Y/48/25/PL

Church Farm House Church Road Yapton BN18 0EP

Removal of tennis court and construction of 1 No self-build single storey energy efficient dwelling.

Martyn White
Principal Conservation Officer, Planning

CHURCH FARM HOUSE - PROPOSED ELEVATIONS

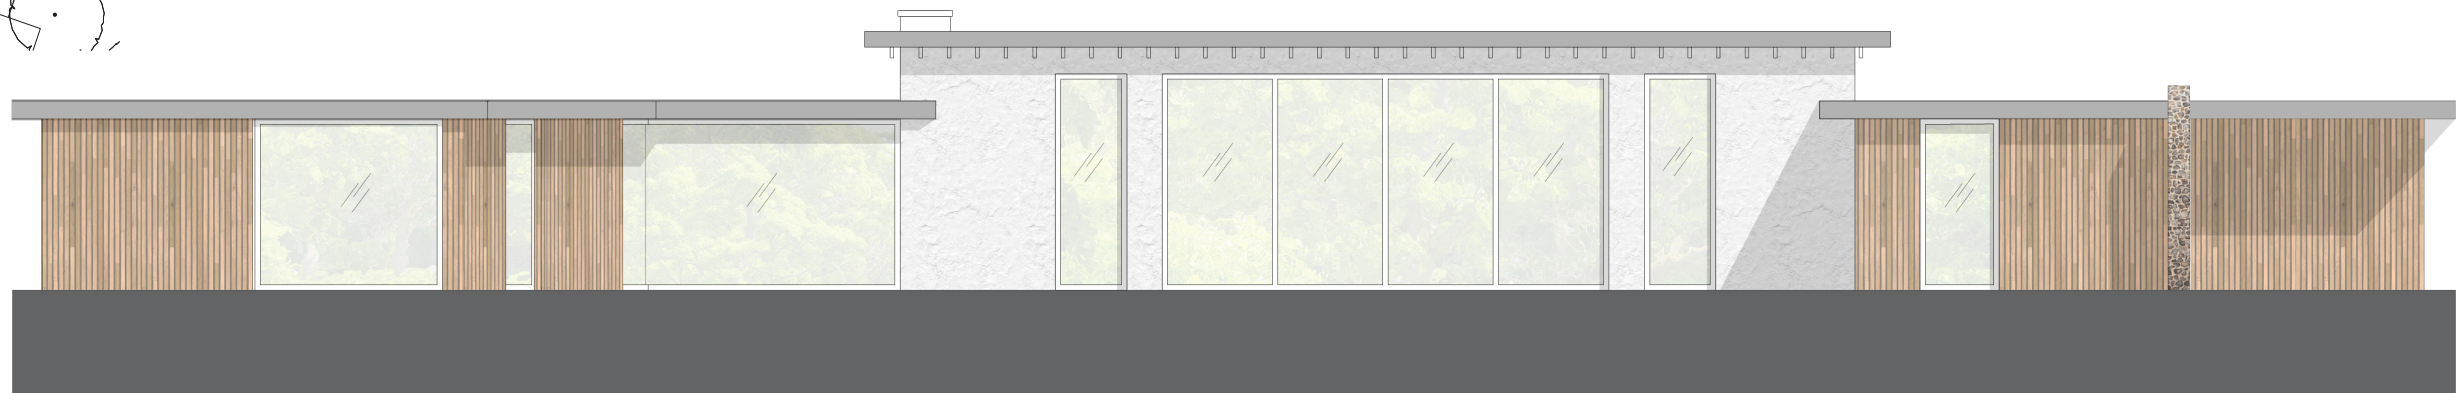
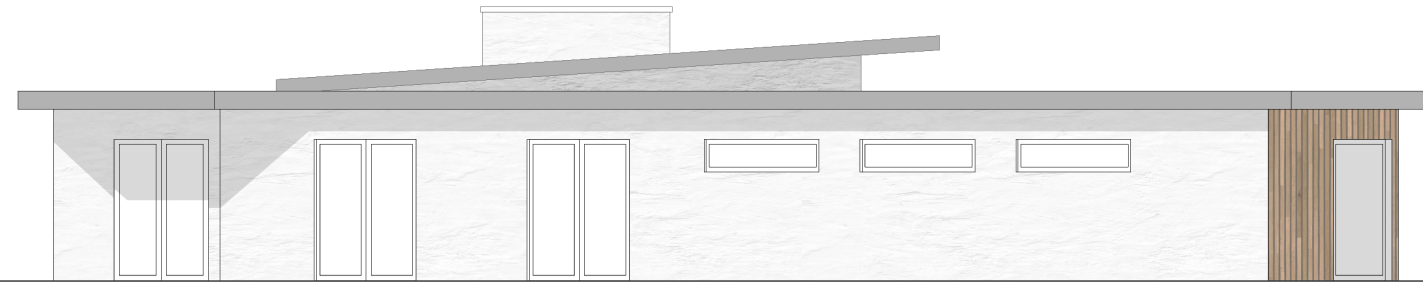
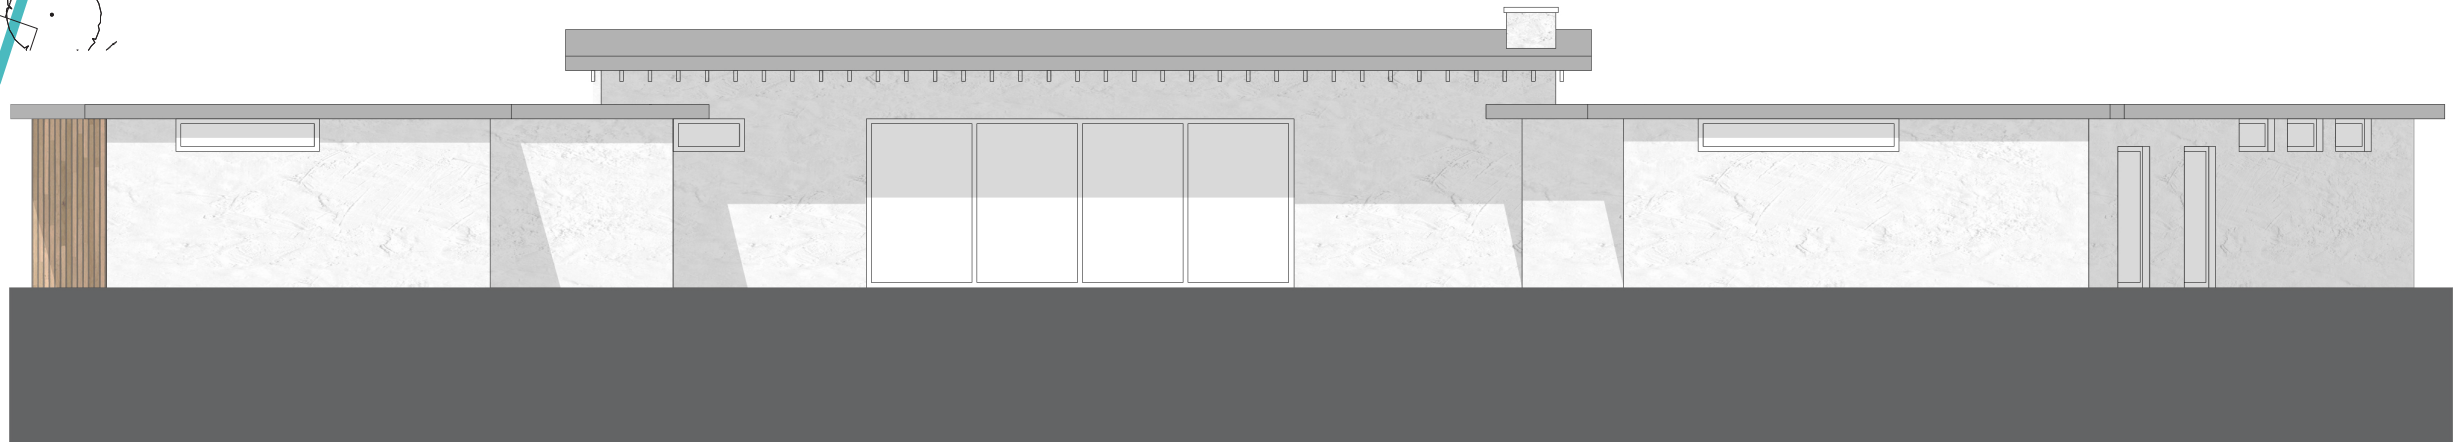
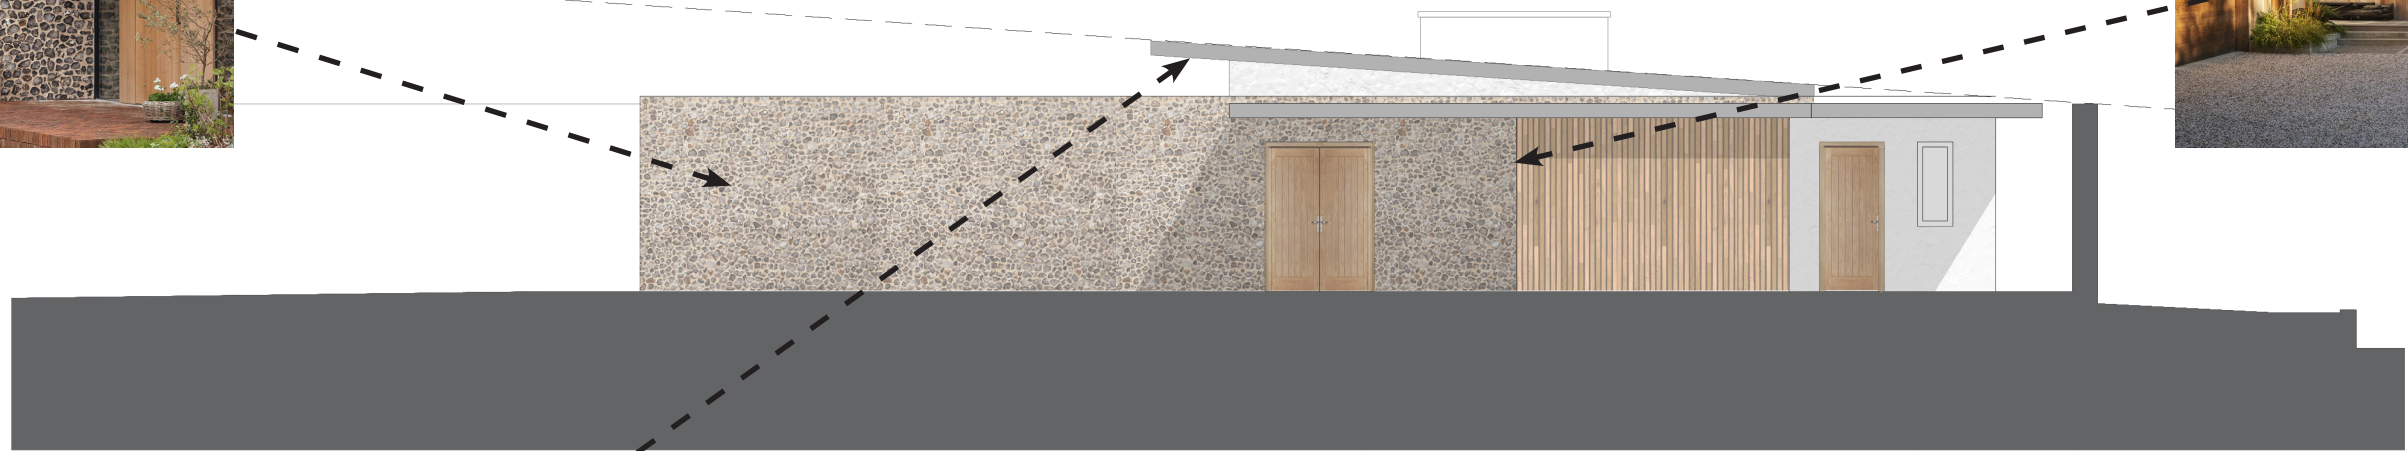
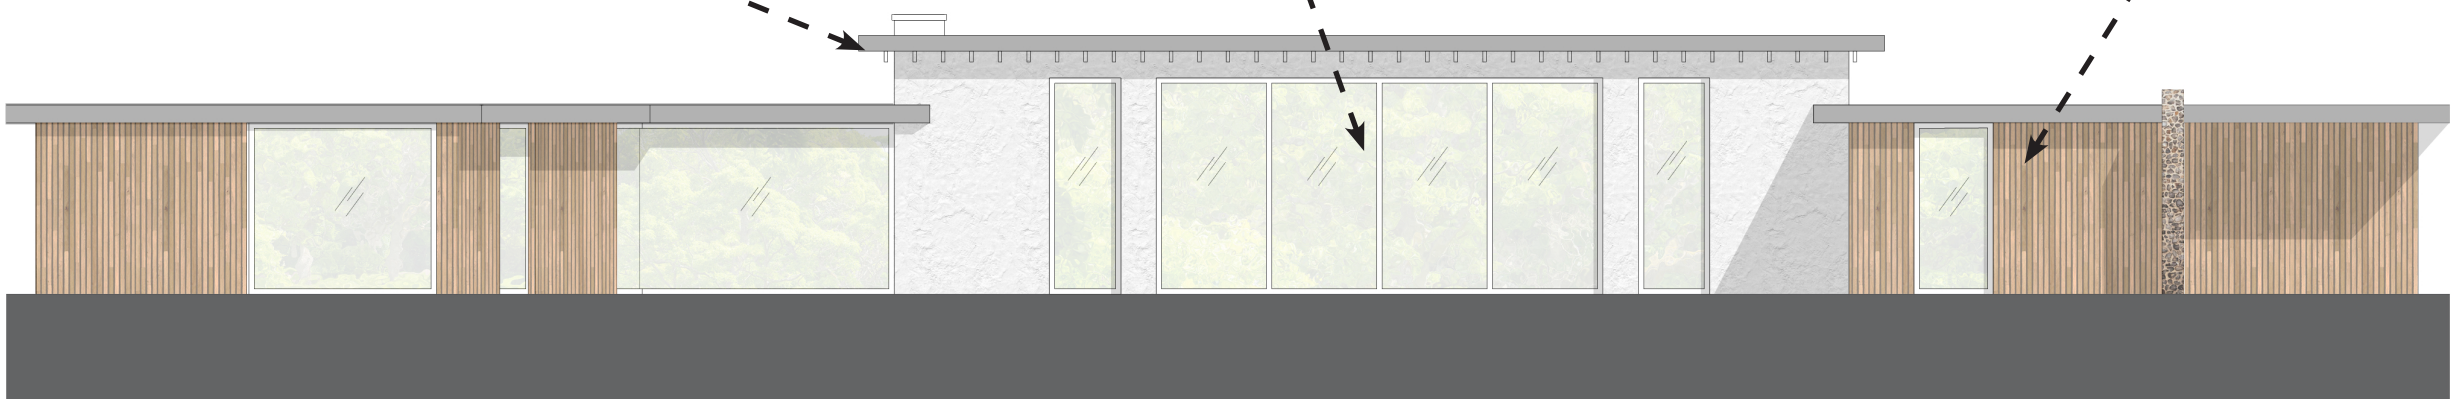
Given the significance of the historic environment in this verdant and attractive part of the conservation area, I believe that much more detail must be submitted in order for a better understanding of how the building will look. This is essential to demonstrate the high quality of design, detailing, materials, and finishes required for the proposal to be acceptable, particularly in light of the site's proximity to the Grade I listed St Mary's Church.

While the submitted plans suggest the potential for a high-quality design, this must be confirmed through the inclusion of larger-scaled drawings. These should cover fenestration, doorways, fascia's, rainwater goods, and external wall treatments.

CHURCH FARM HOUSE - PROPOSED MATERIALS

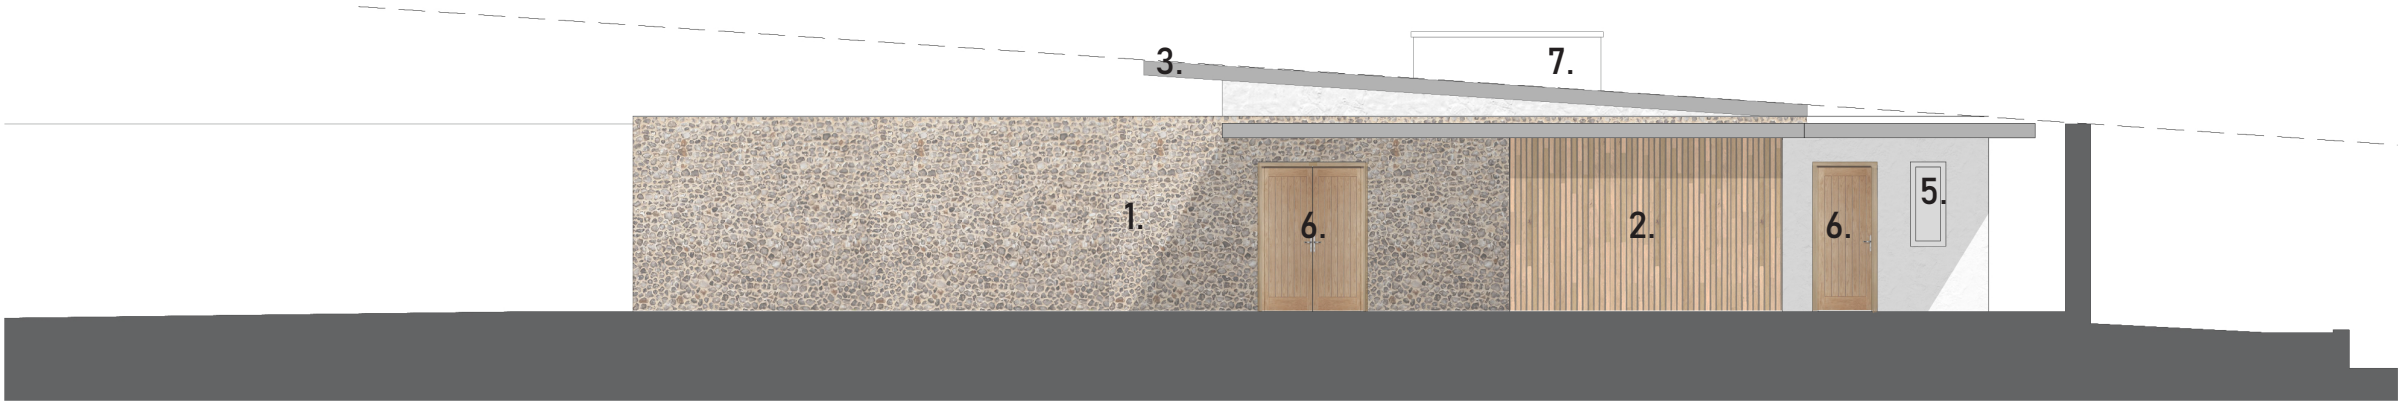
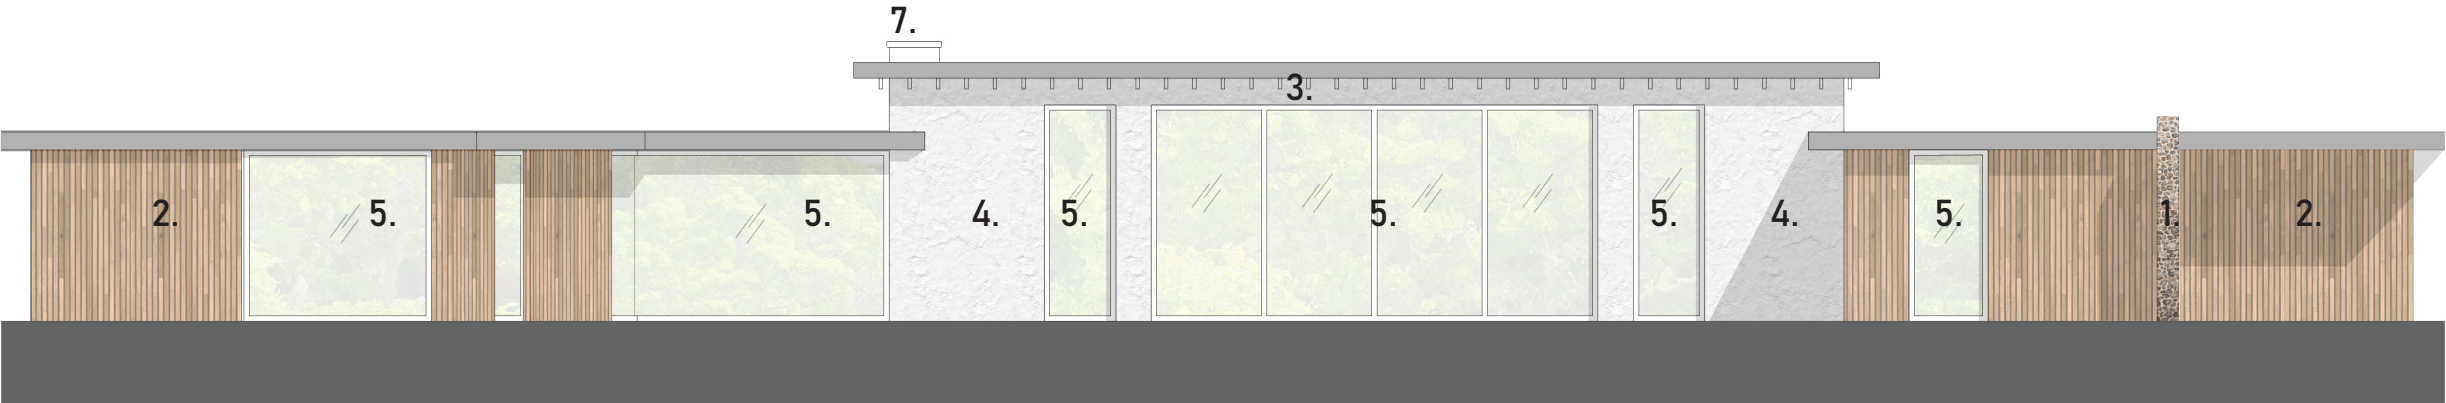
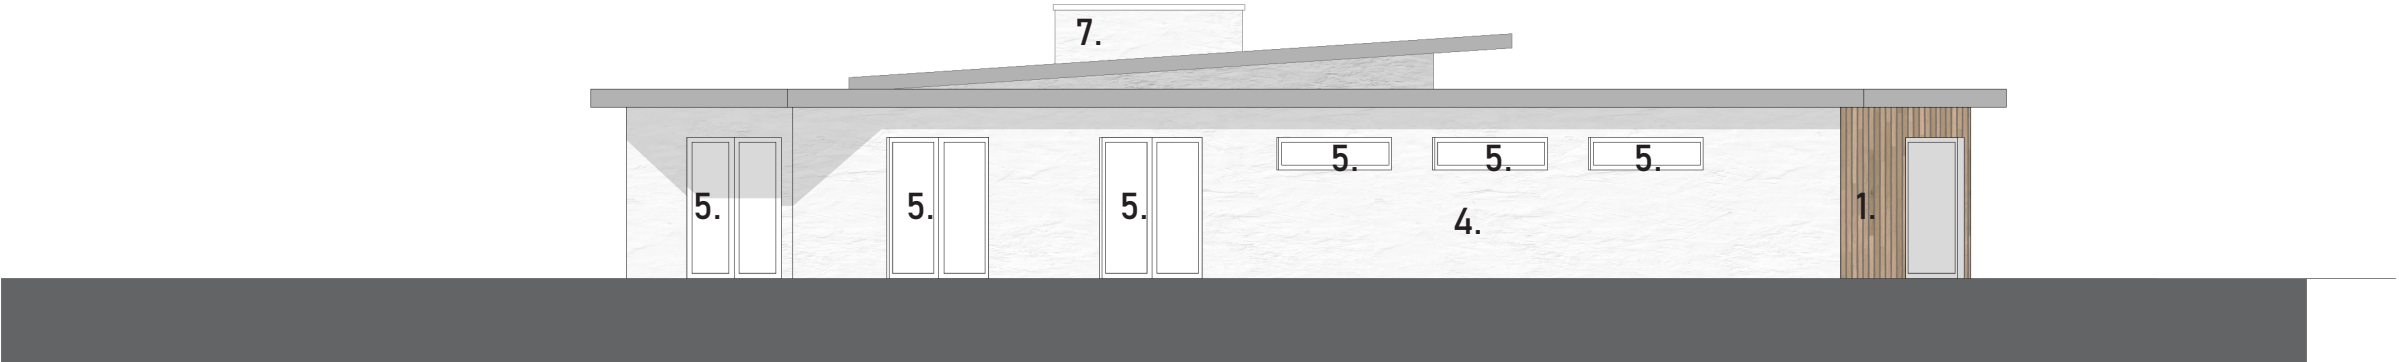
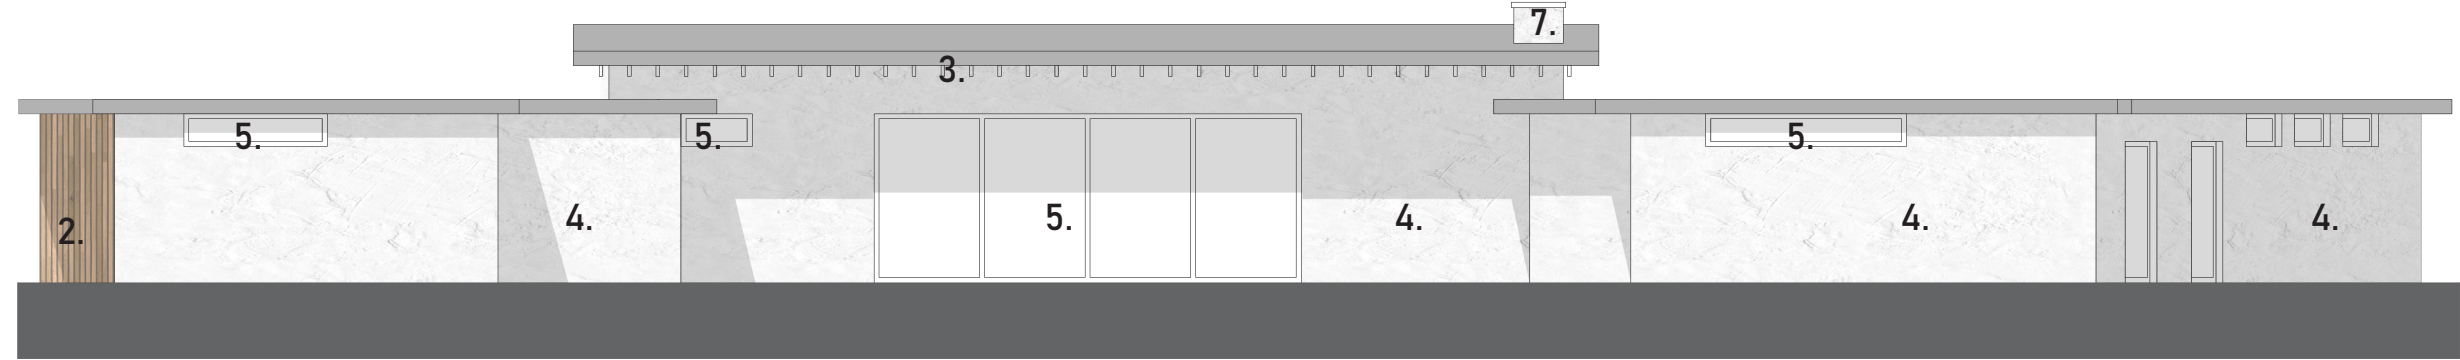
Materials sympathetic to the conservation area are proposed, including flint, which is positive, as it supports the principle of using locally distinctive materials to reinforce character. However, the acceptability of these materials will depend on their quality and execution, and a sample panel should be required.

Figure 2: Proposed site plan

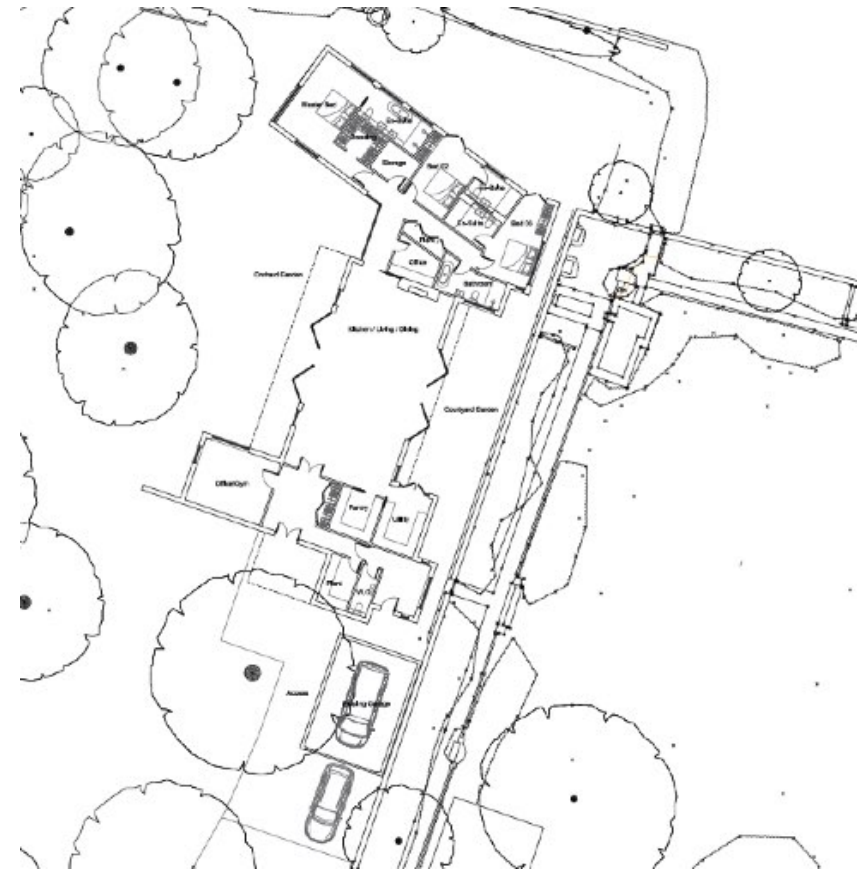
Although there are numerous mature trees within the site, their long-term retention cannot be guaranteed. Furthermore, a review of the site location plan reveals that the area within the red line boundary does not include the access route or the land closest to Church Lane. As a result, the definition of the site's southern boundary is unclear, and it is uncertain how the proposed dwelling would be integrated into the surrounding landscape.

Given the semi-rural character of the area and its heritage context, it is recommended that a comprehensive landscaping scheme be submitted as part of the application. This should include additional tree and shrub planting using appropriate native species to help soften the visual impact of the new building when viewed from Church Lane (and also the approach to Church Farm House). It may also be necessary to adjust the red line boundary southwards to accommodate this planting and ensure a coherent landscape strategy.
